ENG-EGP22006-R1-GEC.pdf Markup Summary

Subject: Stormwater Comments Color
Page Index: 1
Date: 3/14/2023 4:42:40 PM
Author: dotprete
Color: ■
Layer:
Space:
Page Label: [1] 1 2514207CV02 - CV01

GRADING AND EROSION CONTROL PLANS - FILING 5
 GRADING & EROSION CONTROL PLANS
 SHEET 5 OF 9
 JOB NO. 25142.07

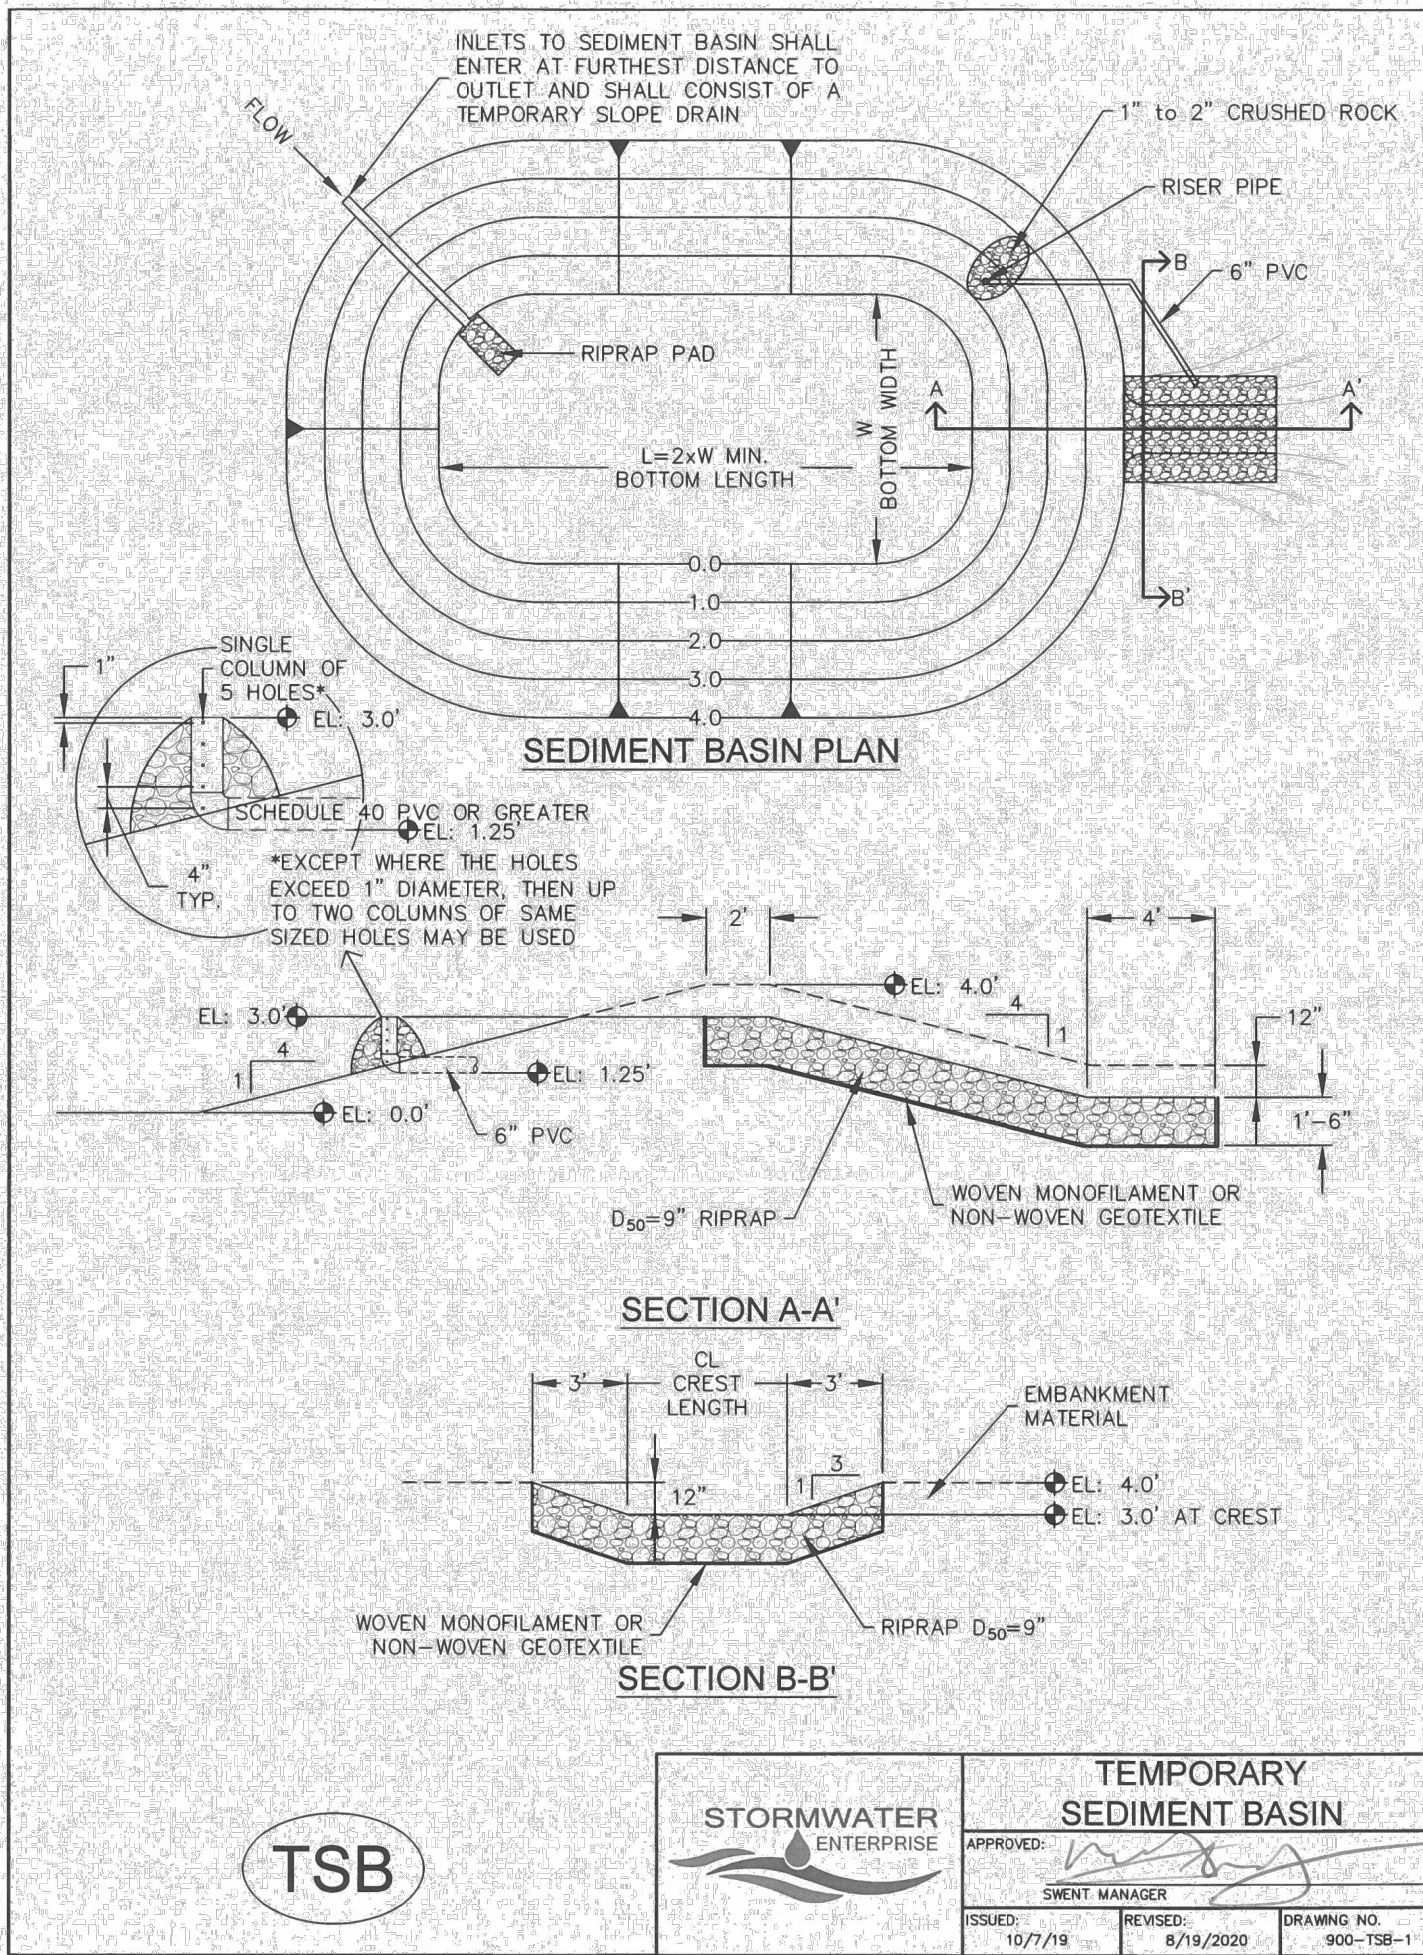
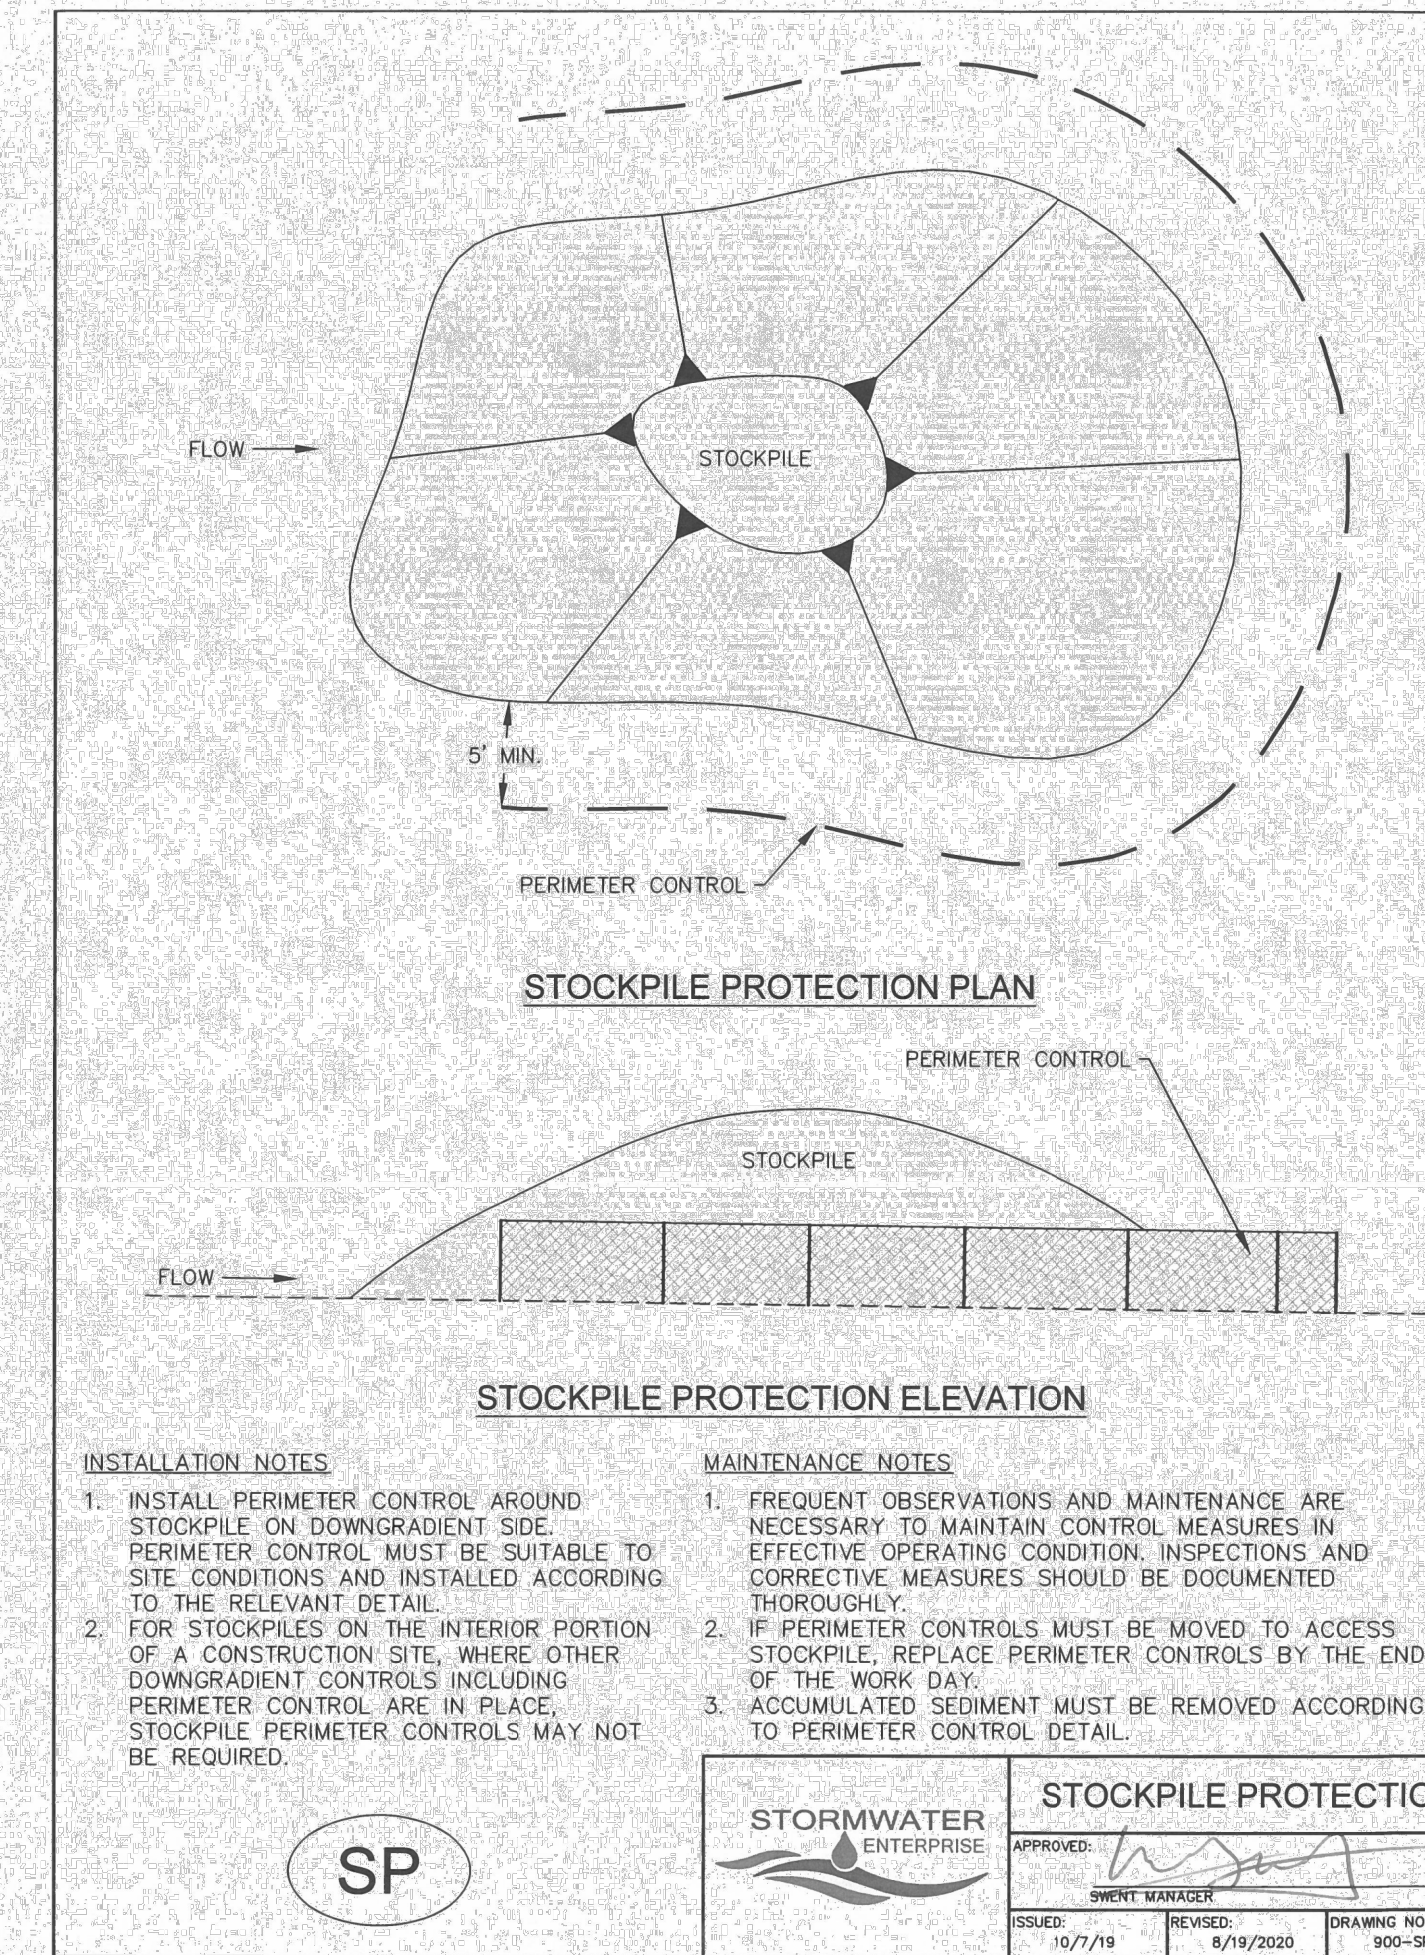
since this is an EGP, remove this bullet and keep BMPs in place for subsequent construction

show the TSB spillway location

show the TSB spillway location

add silt fence

Need owner permission to grade offsite. Provide copy of owner permission to EPC.

show on plans

Is an offsite easement required?

Spillway should be on this side to minimize impacts to downstream property

Call out grading in the SFHA and discuss permitting with the Regional Floodplain Administrator
